**FOSSE GREEN ENERGY DEVELOPMENT CONSENT ORDER**

**PINS REFERENCE EN010154**

**DEADLINE 3: NATIONAL HIGHWAYS'  
RESPONSES TO EXQ2**

Solar Perimeter Fencing

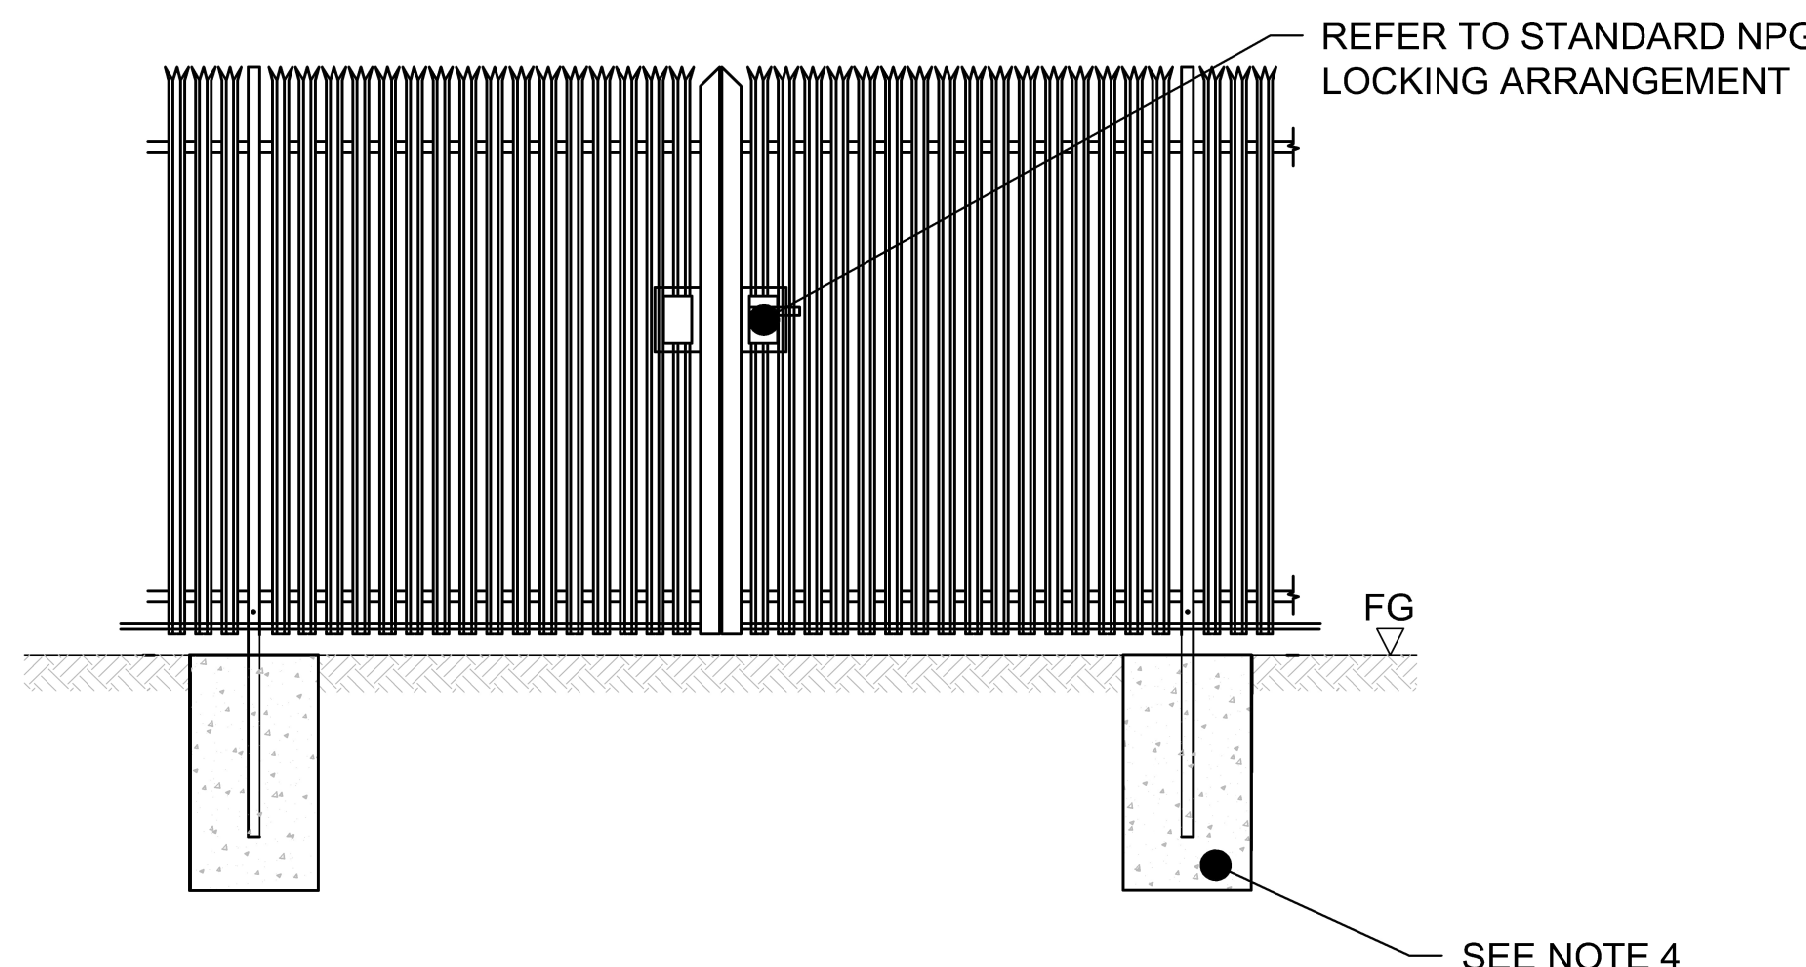
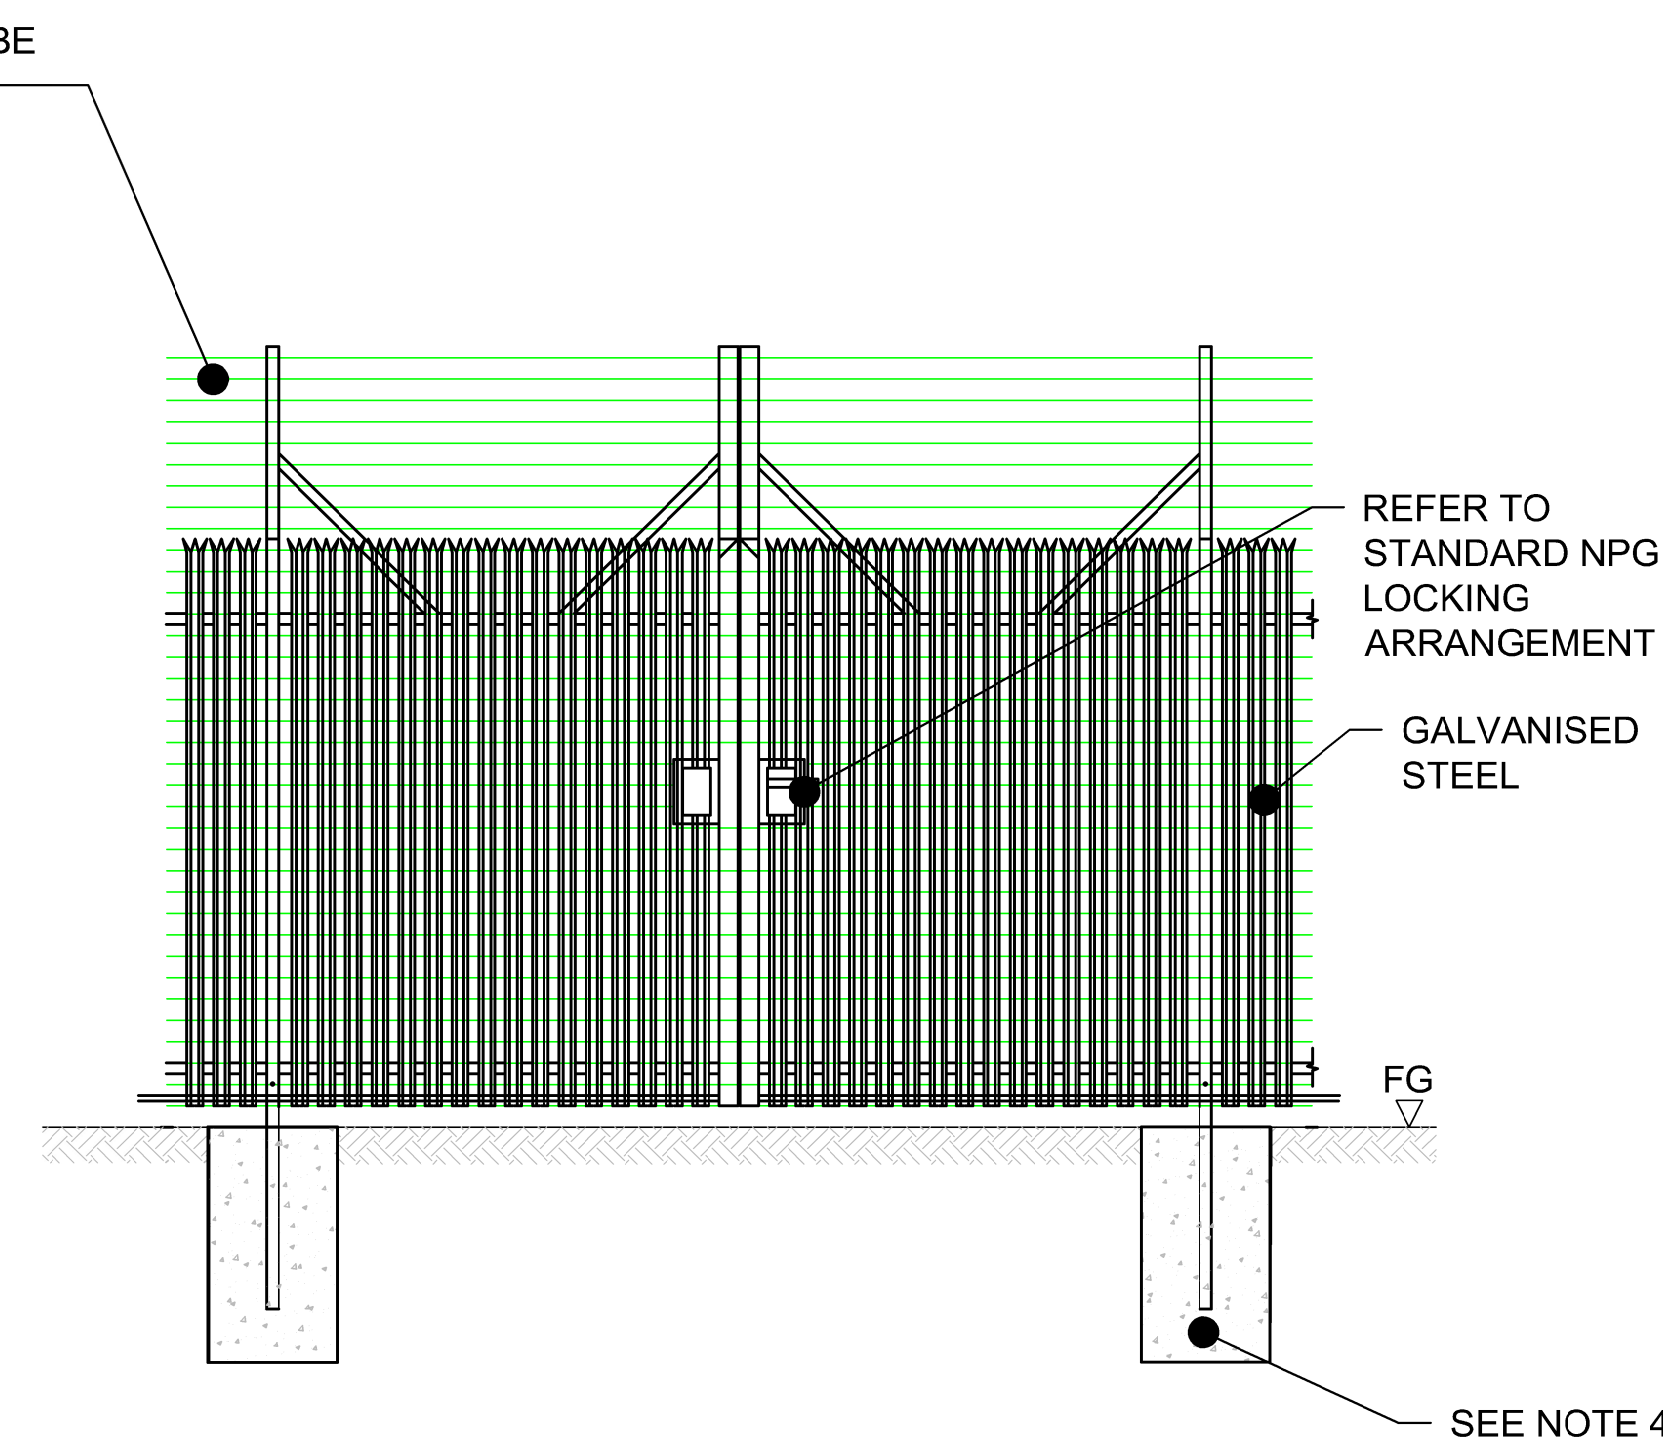
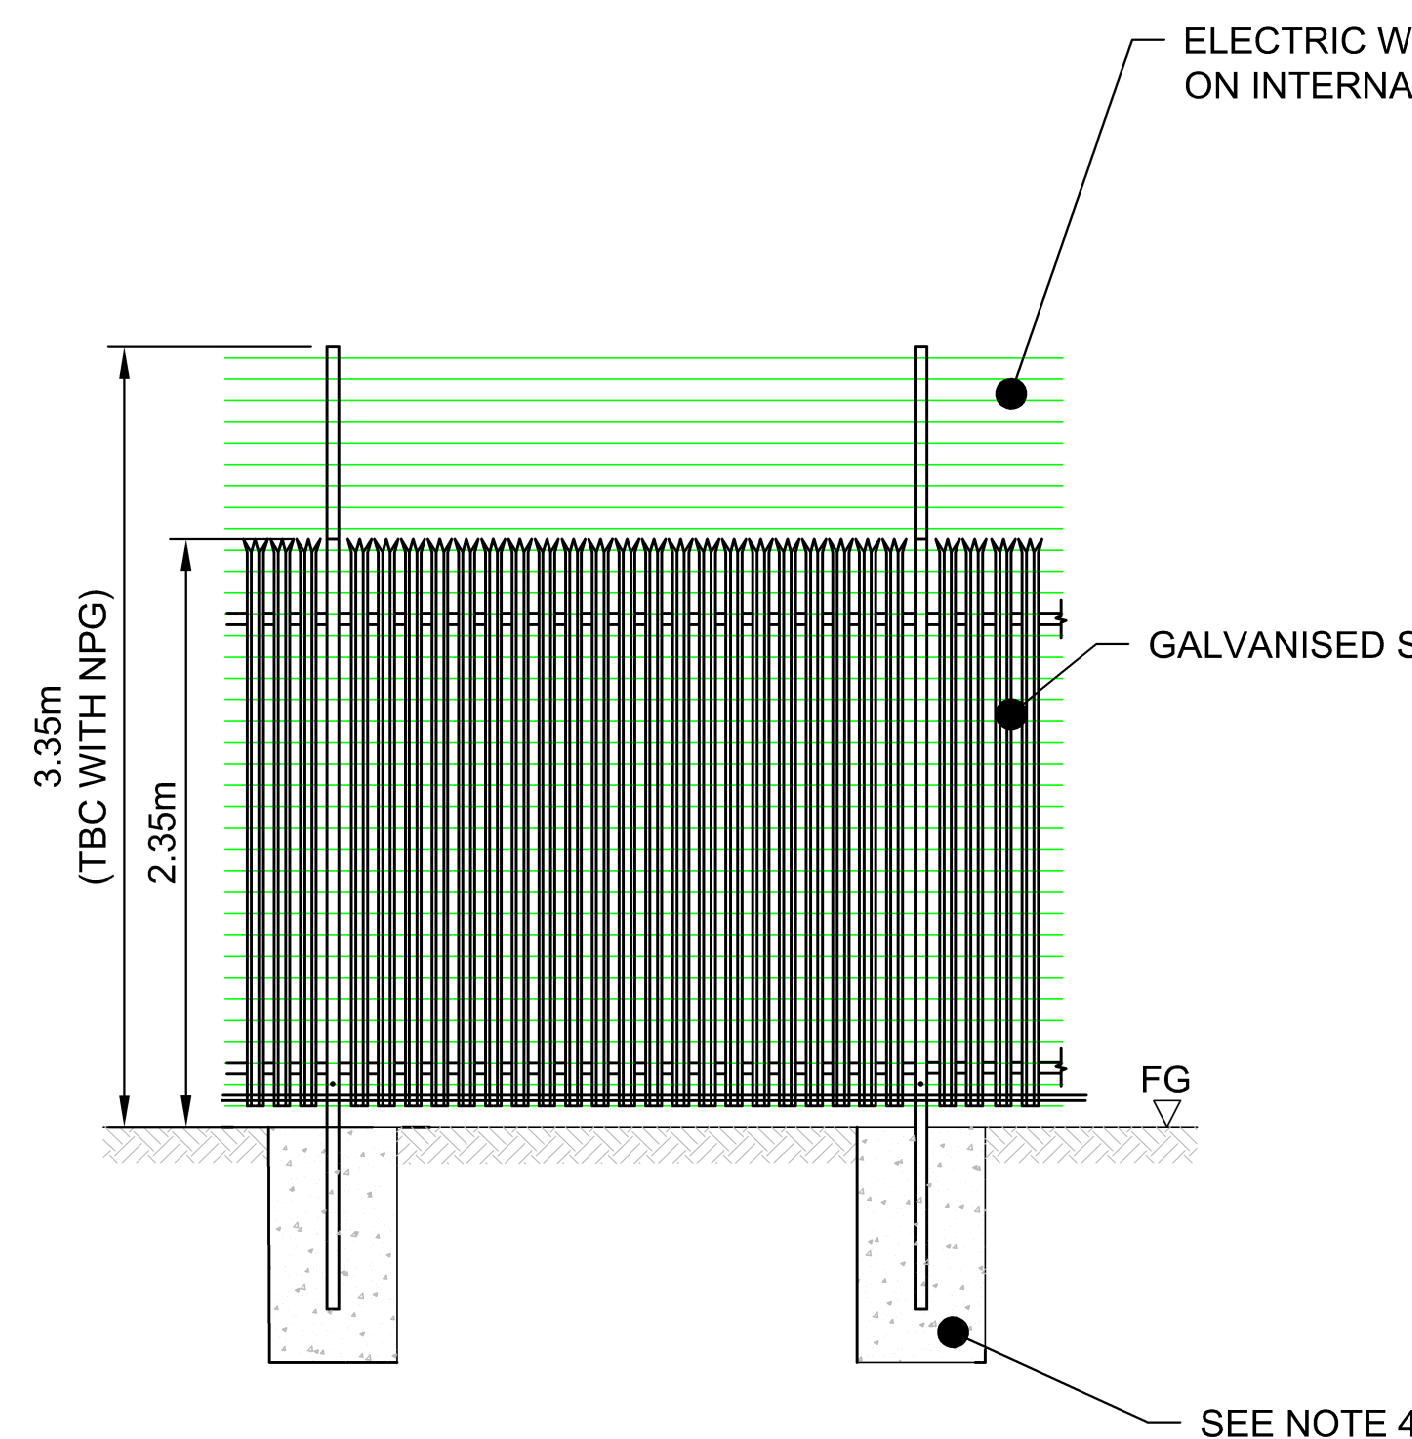
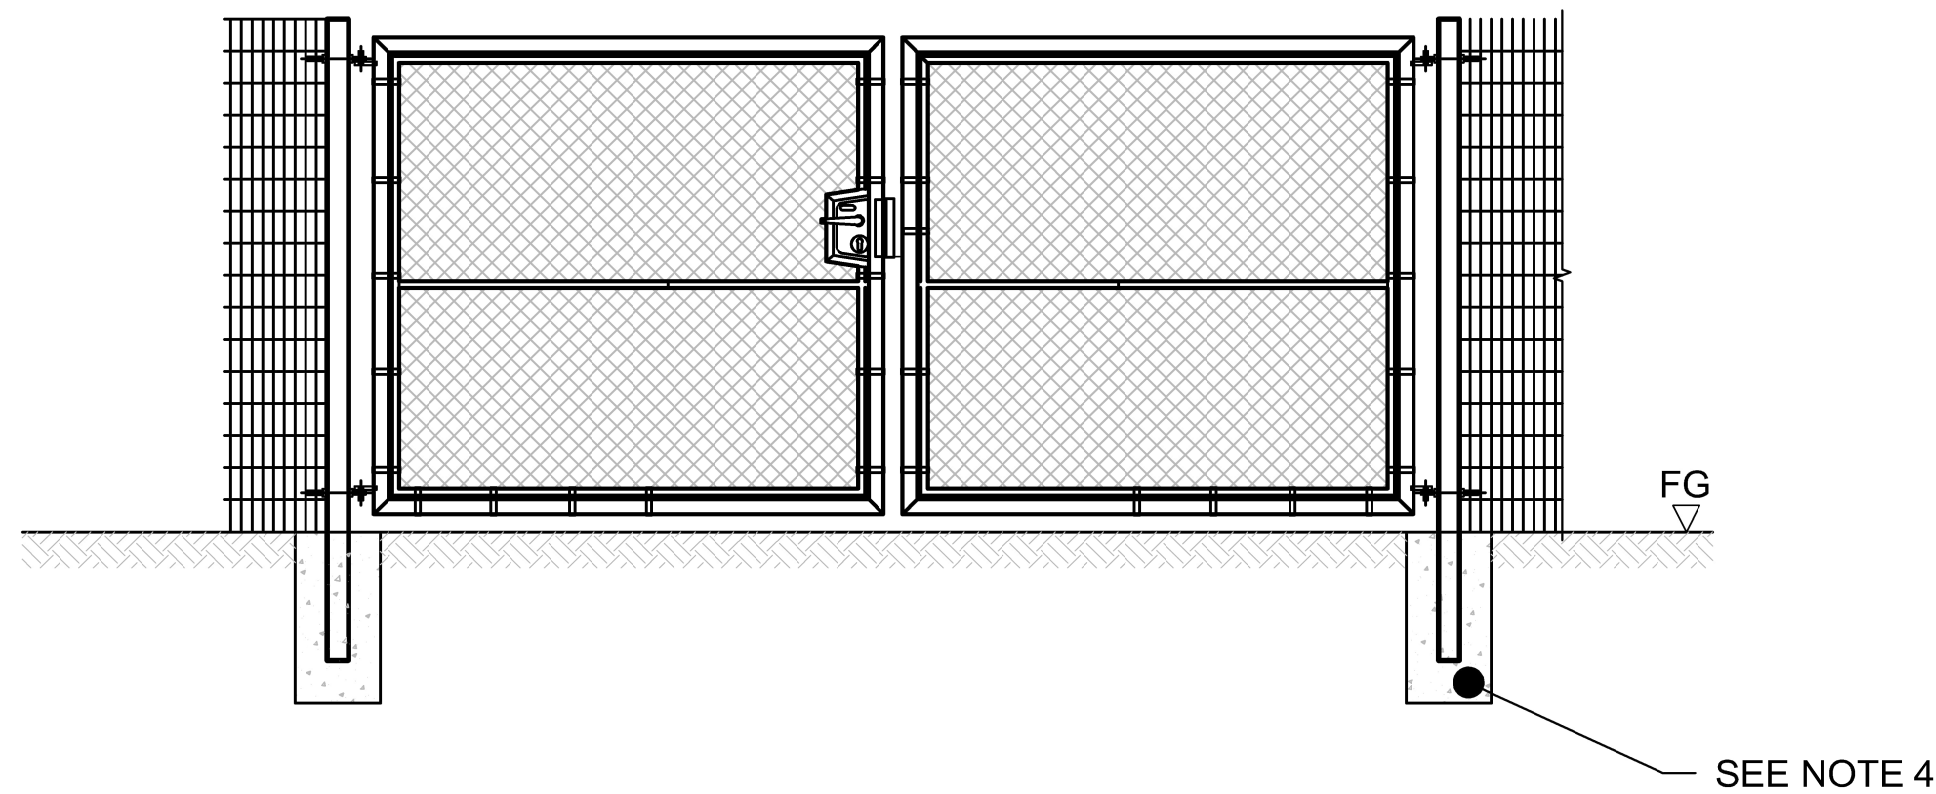
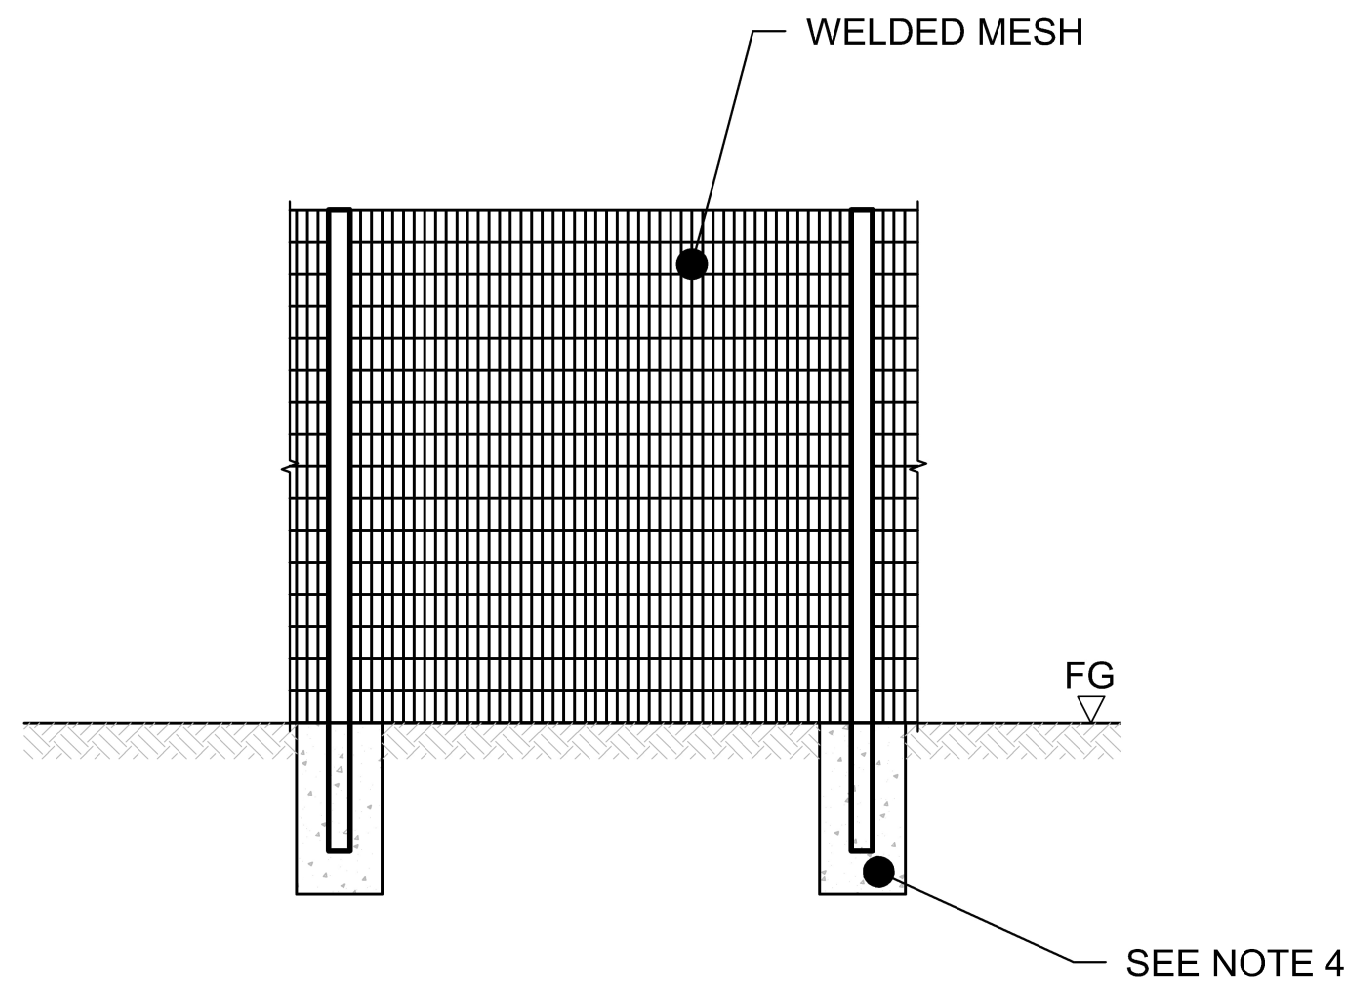
<u>Question number</u>	<u>Question to</u>	<u>Question</u>	<u>National Highways response</u>
DCO.2.15	National Highways	<p><b>Requirement 9 (Fencing and other means of enclosure)</b></p> <p>In [REP2-052] you have advised further information is required on the proposed fencing and other means of enclosure before you can confirm your position with respect to Requirement 9.</p> <p>On pages 35 and 36 of its post hearing summaries in [REP2-032], the applicant signposts the fencing details and identifies that the FCEMP was updated at Deadline 1 to confirm that any fencing would be located behind existing hedgerows adjoining the A46.</p> <p>a) Does the information provided in [REP2-032] address your concerns about fencing and other means of enclosure?</p> <p>b) If not, would you want the applicant to submit further details during the examination (and if so what) or would being added as a consultee to Requirement 9 address any remaining concerns about fencing and other means of enclosure you have?</p>	<p>NH has reviewed the documentation submitted by the Applicant at deadline 1 and is now satisfied with the proposed fence locations.</p> <p>These appear consistent with Strategic road network and the delivery of sustainable development Circular 01/2022 requirements. Therefore, NH no longer seeks to be consulted on Requirement 9.</p> <p>It is noted that the proposed fence line does sit directly behind the existing hedgerow adjacent to the A46. It is possible during installation, damage could be caused to the roots of the hedgerow due to the close proximity. Should damage be caused to the hedgerow to insecurely root the plant, NH may seek to remove the hedgerow under its powers under the Highways Act 1980 should it become a safety concern and threat of falling down on the adjacent A46.</p> <p>This further support NH's request to be a named consultee on Requirement 8 Landscape and Ecological Management Plan (LEMP) of the draft DCO, which states that existing hedgerows are being relied upon for glint and glare mitigation. Therefore, any damage to these hedgerows during the installation of the fence may effect the glint and glare mitigation measures proposed in the LEMP. This would be of interest to National Highways.</p>
